# M3J9

# Submission

## Winchester Action on the Climate Crisis

Figure 7-9: Core scenario flows, 2047 AM peak, Do-Minimum and Do-Something scenarios (NB-northbound, SB-southbound, EB-eastbound, WB-westbound)

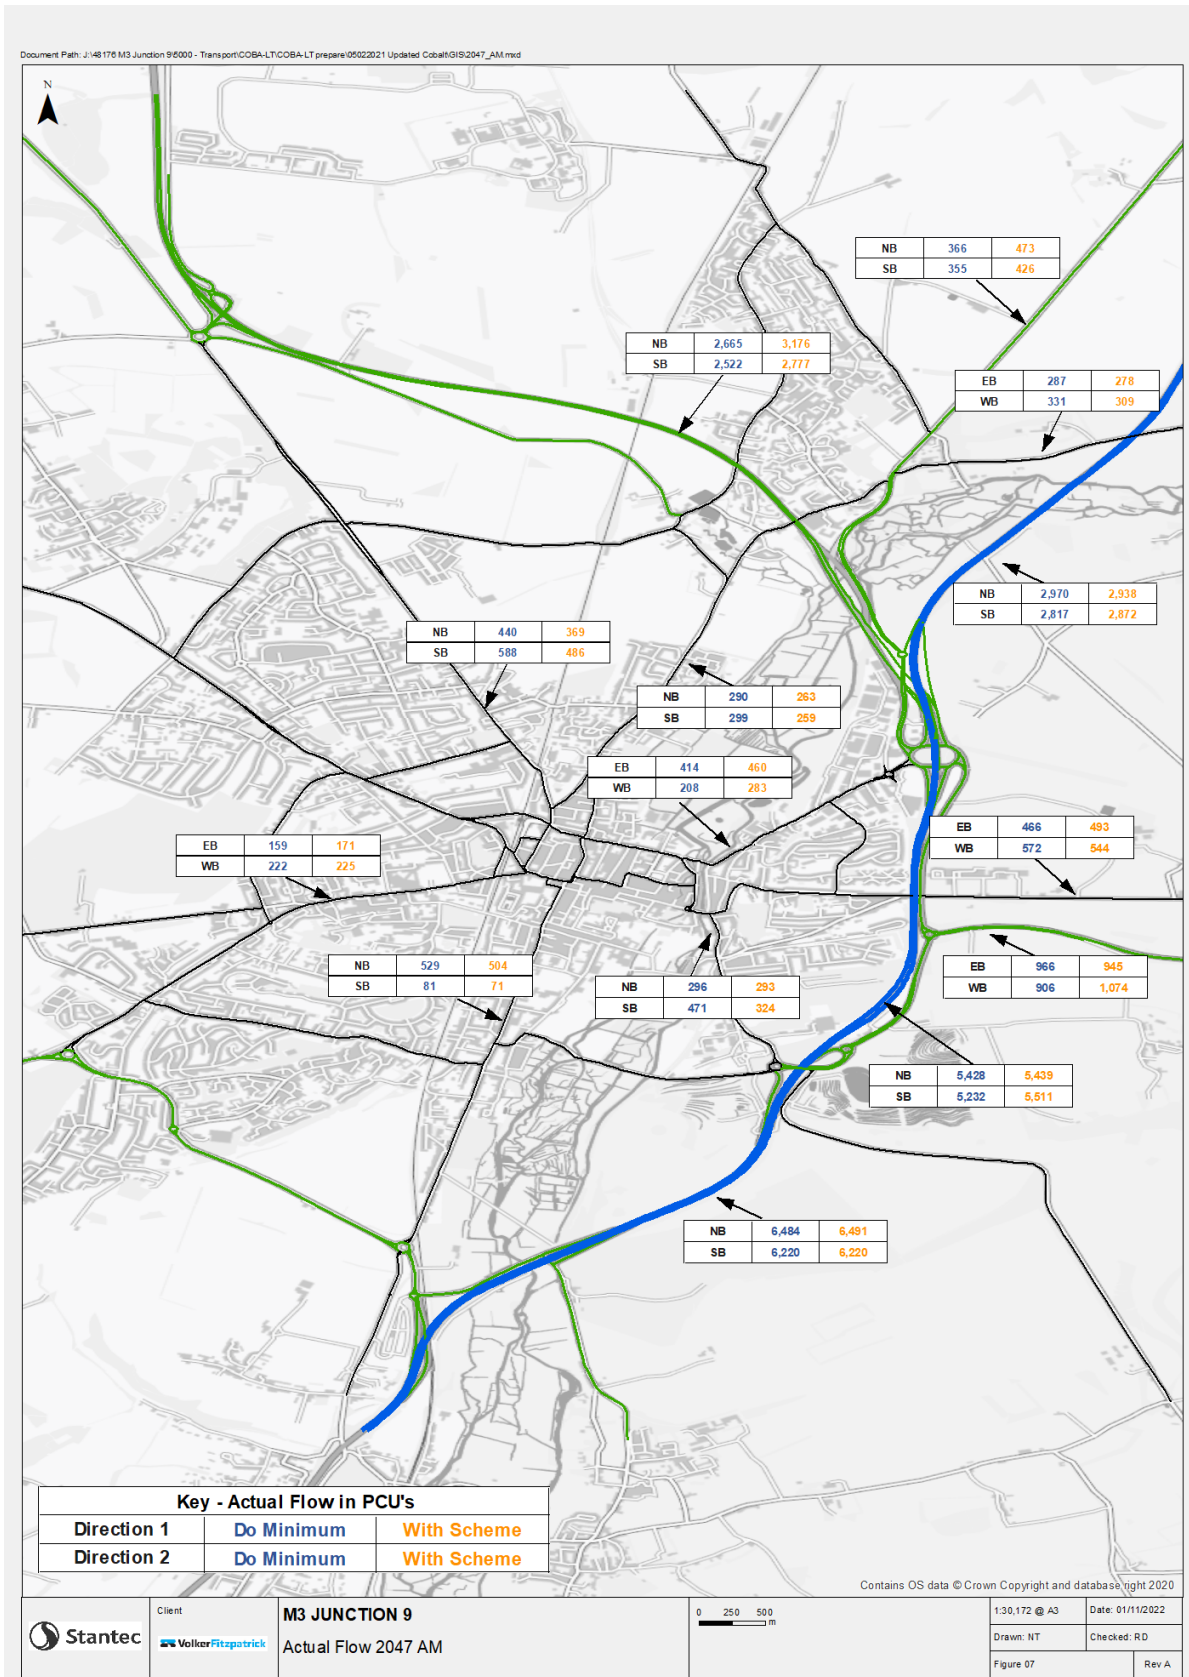
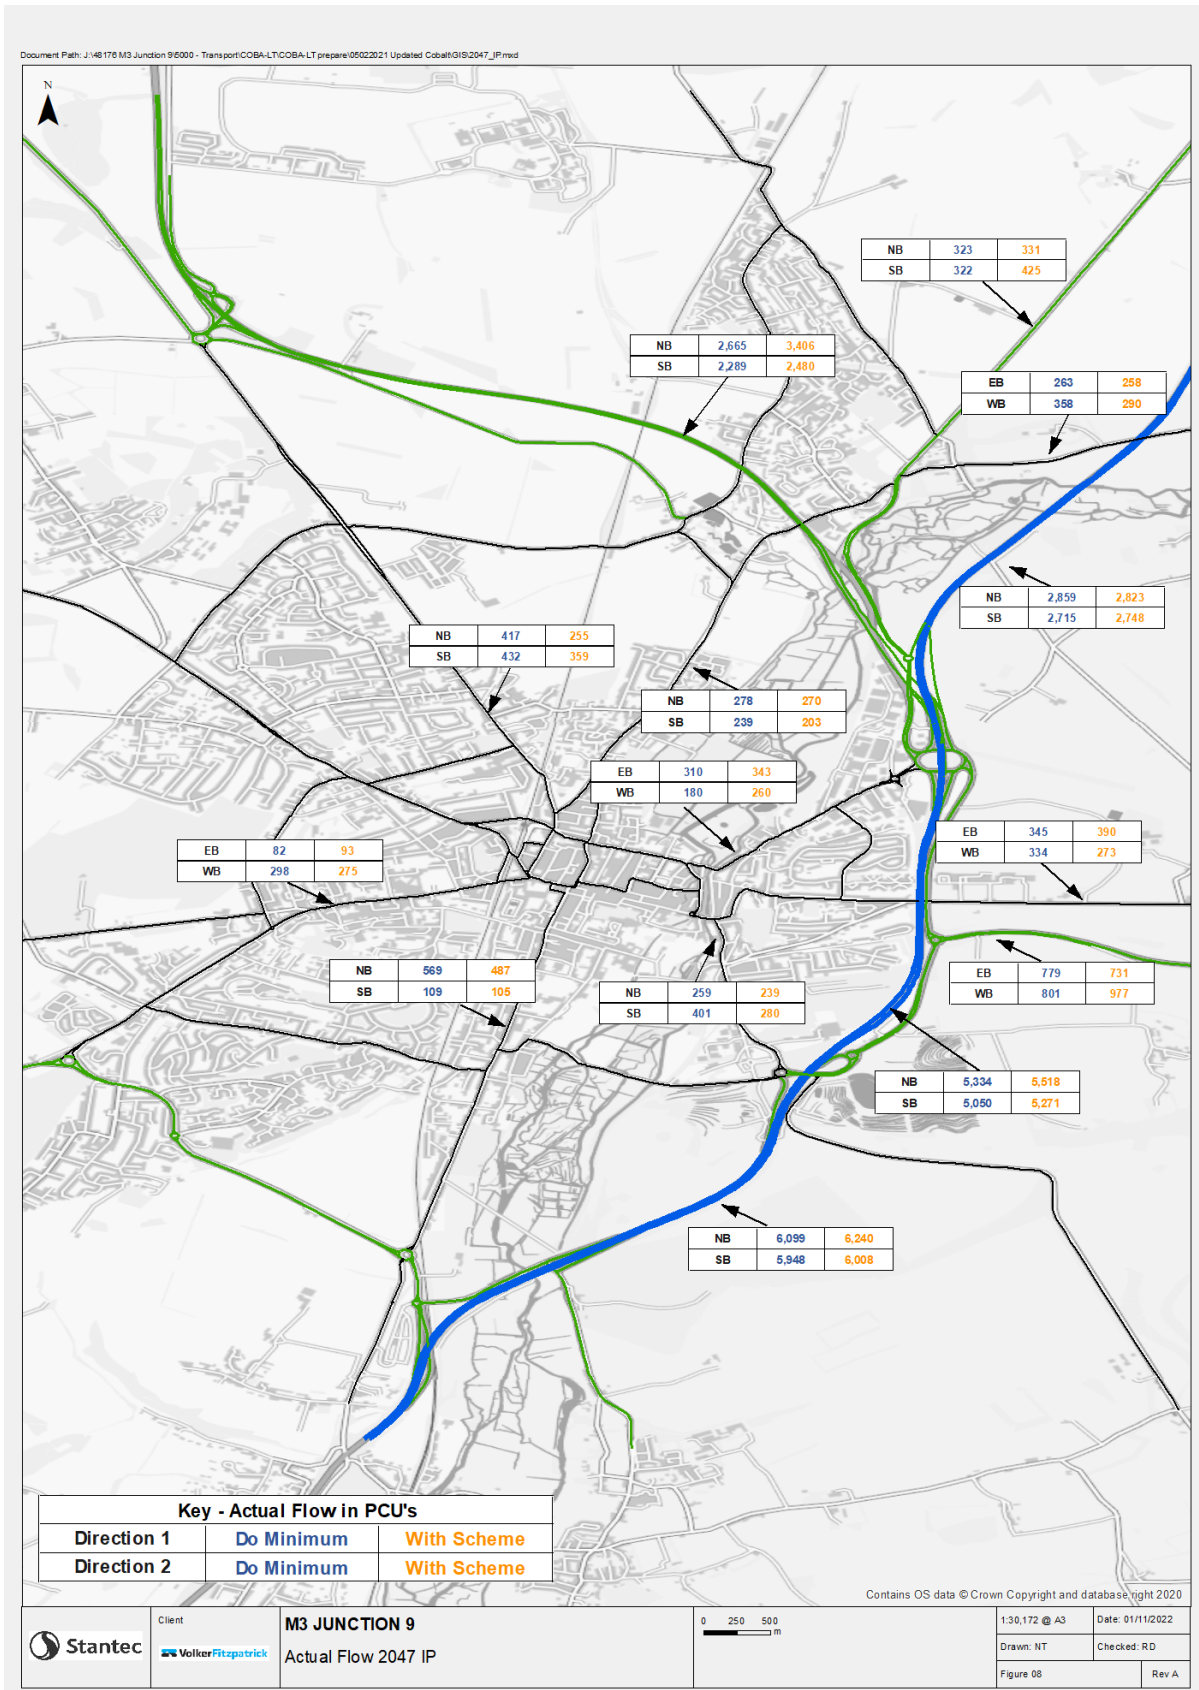
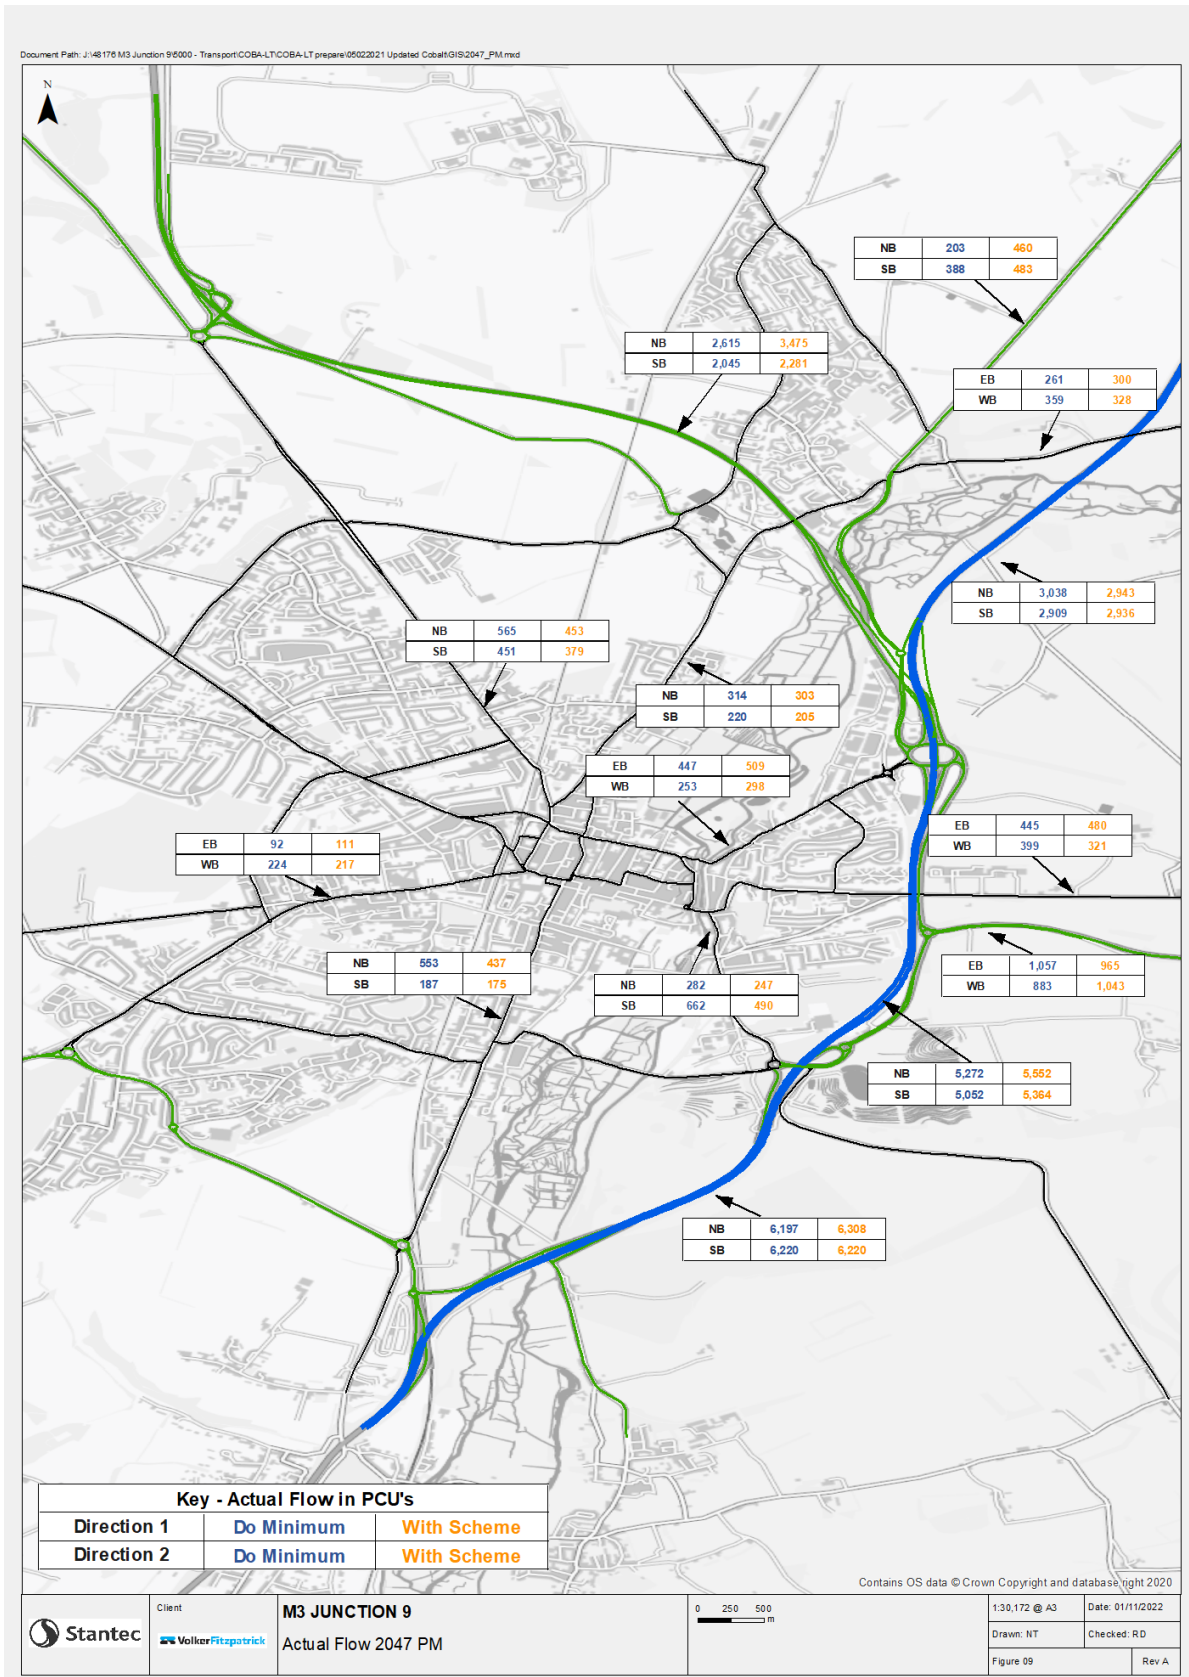
The modelling maps in document [7.10 Combined Modelling and Appraisal Report](#) compare traffic flow if the project does not go ahead (Do Minimum (DM)) with what will happen if the project goes ahead (Do Something (DS)). The final comparison models what will happen in 2047.

In the table below we have added together both directions for the AM peak, the period between the peaks, and the PM peak.

There are some roads that will suffer major traffic increases: especially Easton Lane, and the A34 as it passes through King’s Worthy. Some roads will benefit from major decreases such as Chesil Street and Andover Road.

However the overall picture is one of very little change. It is very surprising that the modellers predict a small reduction in traffic along the M3 from Winchester to Basingstoke. It will reduce traffic levels within Winchester Town very little.

The report above accepts that induced demand is a significant phenomenon. In the worst cases, especially where there is traffic congestion, traffic will increase to fill the available space. The applicant proposes doubling (at least) the carriageway width on the route through the junction linking M3S and A34N in both directions. In a situation like this it would not be unknown for traffic to double. This route does show the greatest two-way traffic increase across the 20 year modelling period but the increase of 26% predicted by the modelling understates the likely results of a 100% capacity increase:
